Please ask for: Nicola Moore
Email: nicola.moore@arun.gov.uk
Telephone: Ext 37944
Our Ref: LU/276/20/HH
Your Ref:
Date: 22nd October 2020

Application for Planning Permission for Works or Extension to a Dwelling

Development: Side Extension and 2 storey rear extension (Resubmission of previously approved LU/334/19/HH).
Location: Parkfield Worthing Road Littlehampton BN17 6SH

EXISTING FLOOR PLANS

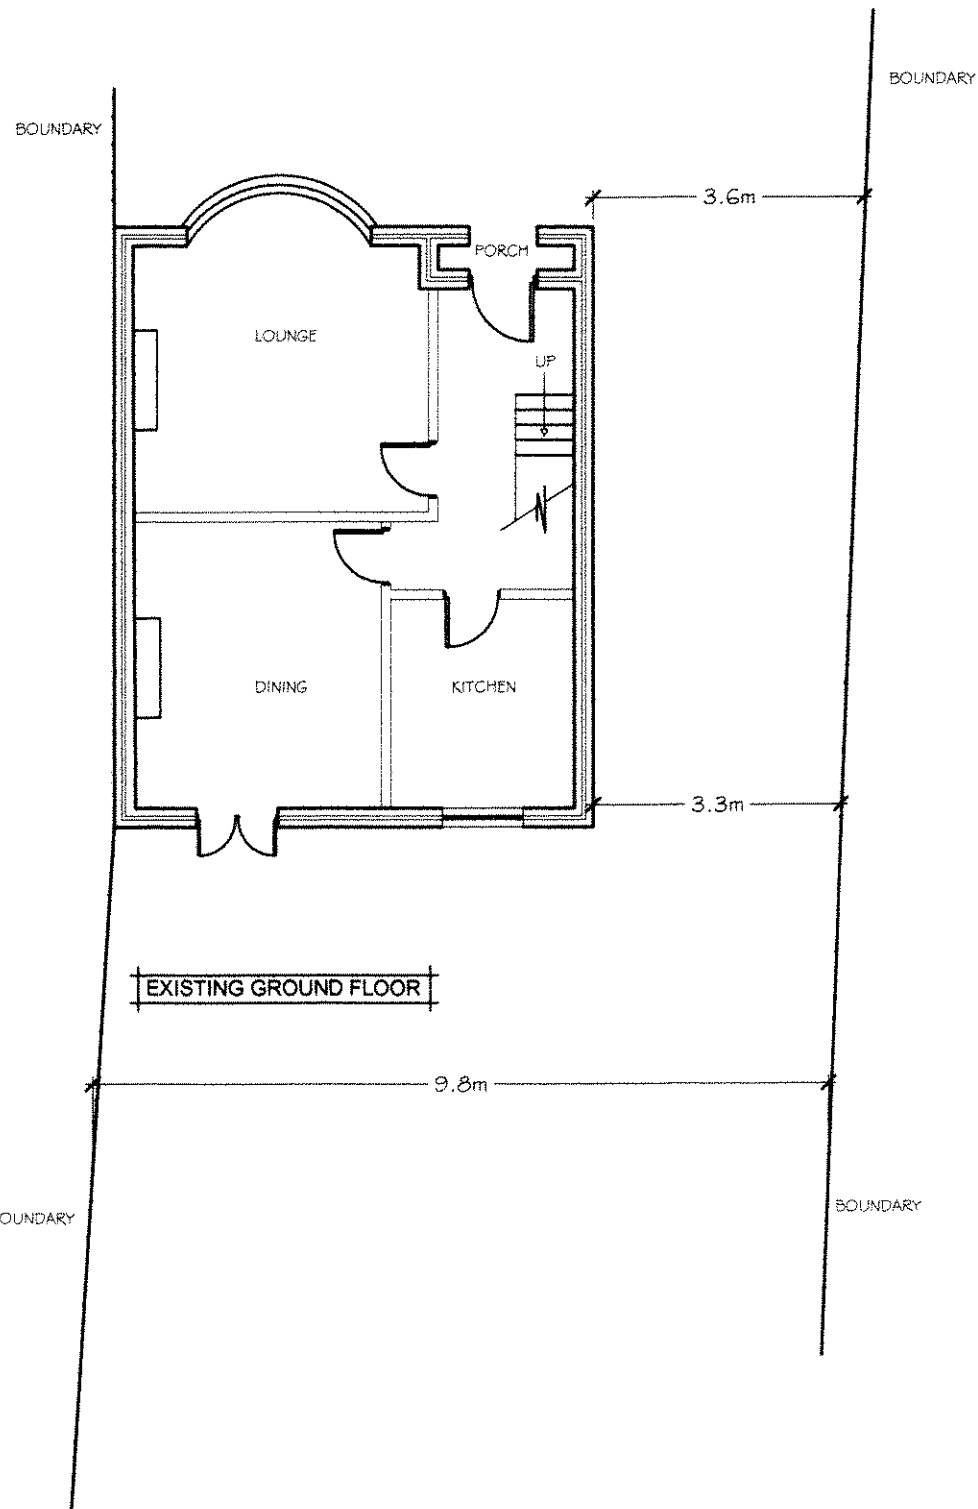
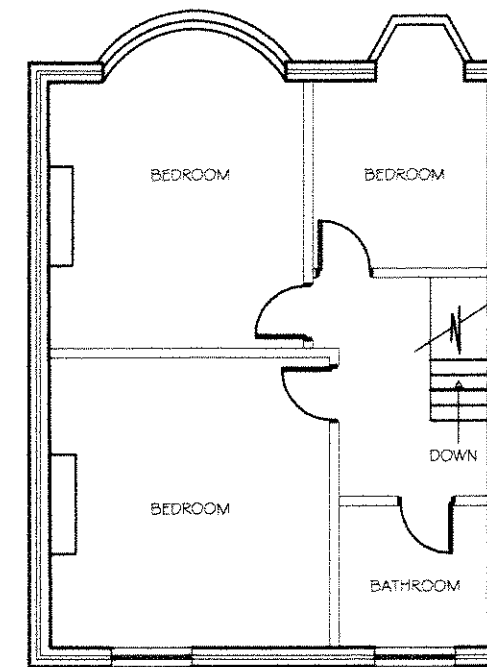
Please submit 1 electronic or 3 paper copies of clearly labelled existing floor plans at a scale of 1:50 or 1:100. Further details can be found in the Validation Requirements List.

PROPOSED SOUTH ELEVATION

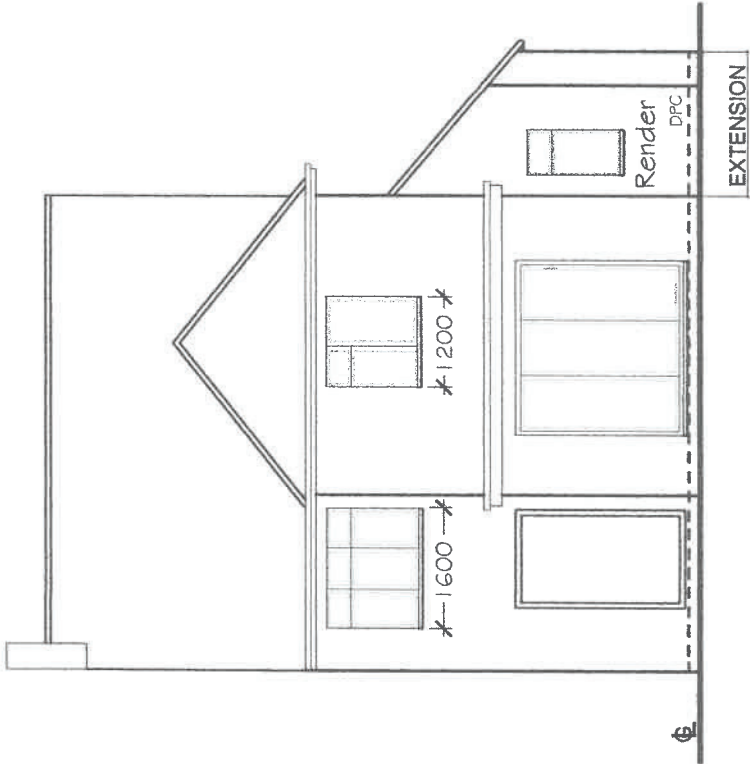
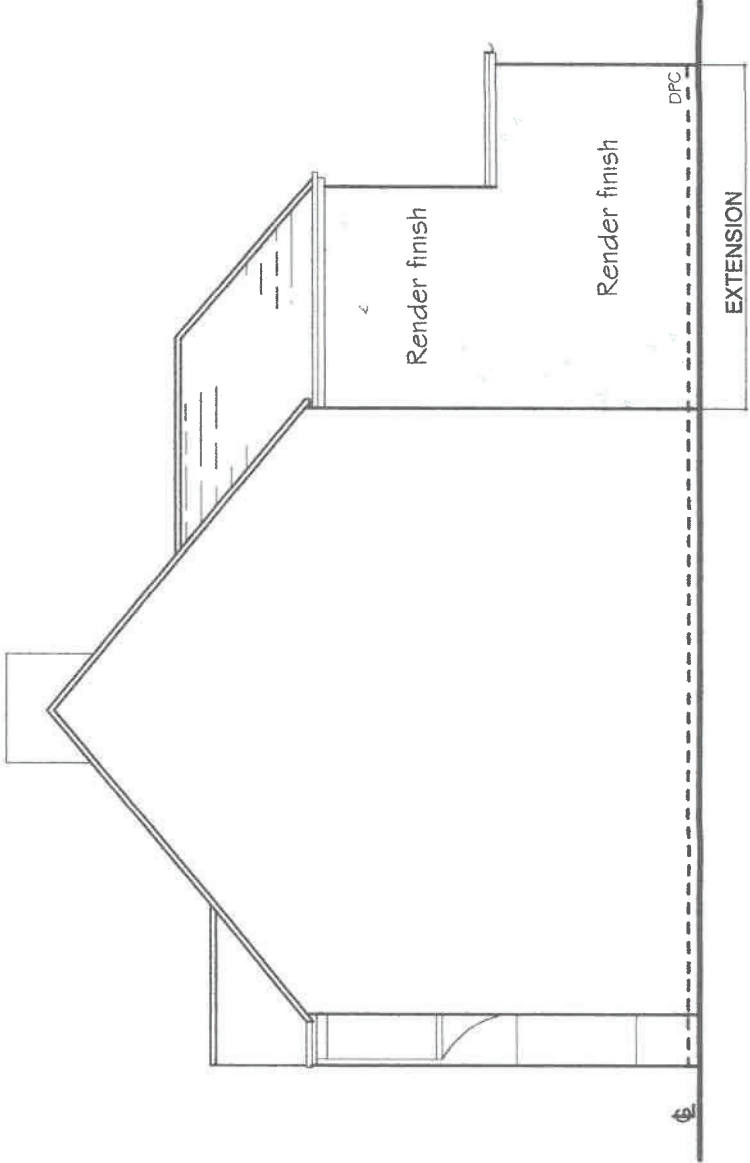
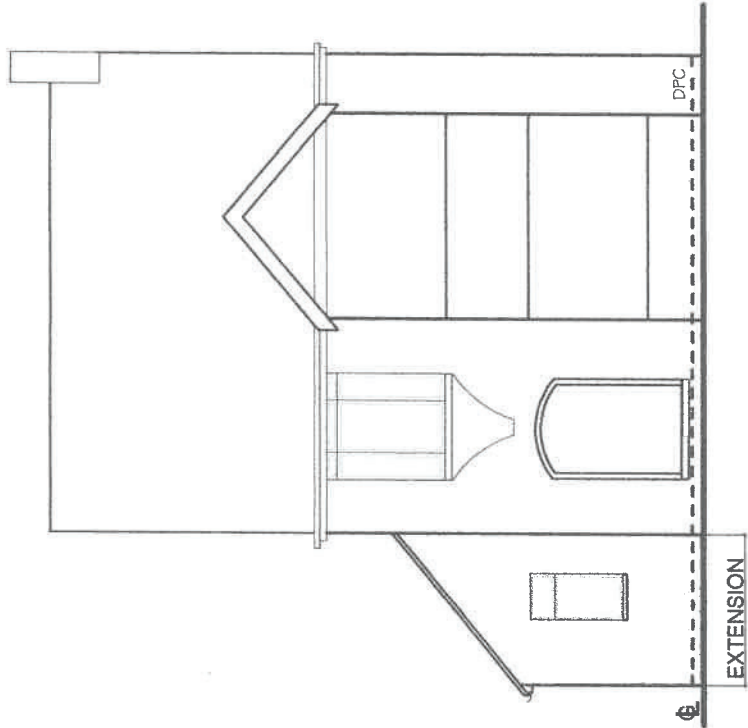
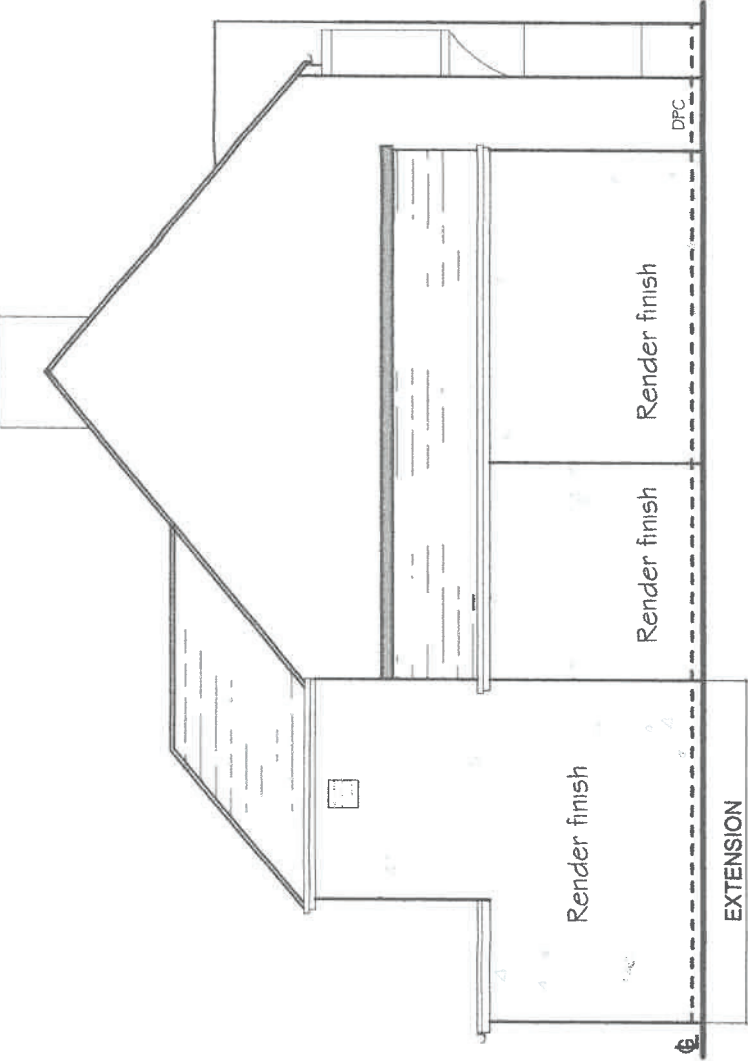
The first floor windows on the South Elevation measure 1.6m and 1.2m on drawing number 03 Proposed Elevations, and 1m and 1.2m on drawing number 04 Proposed Floor Plans. Please check the measurements, amend accordingly and resubmit.

DRAWING
BLOCK PLAN

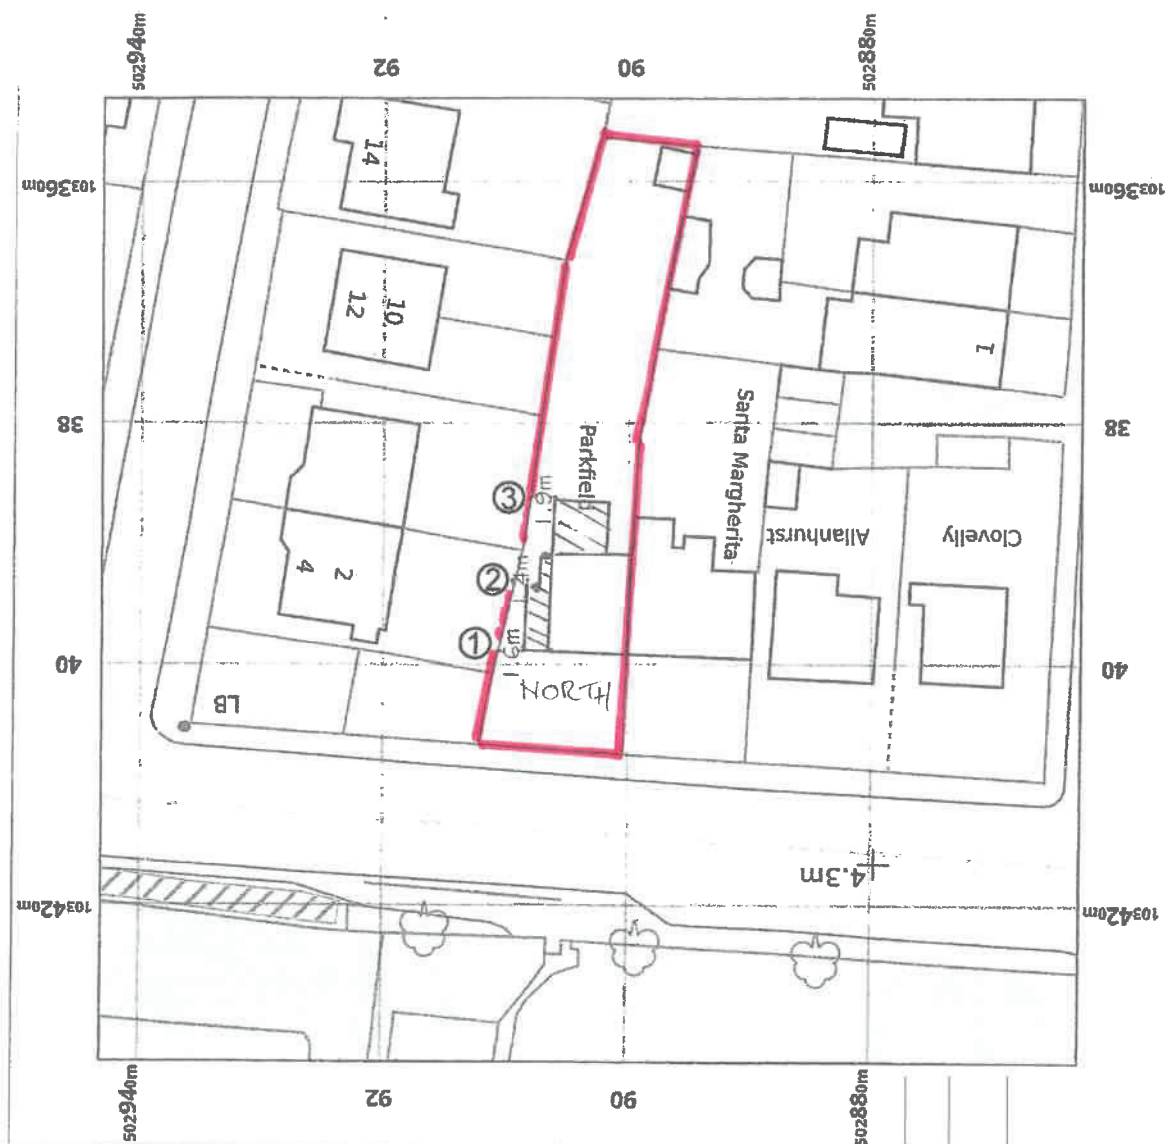
Please include written dimensions to boundaries and re submit.
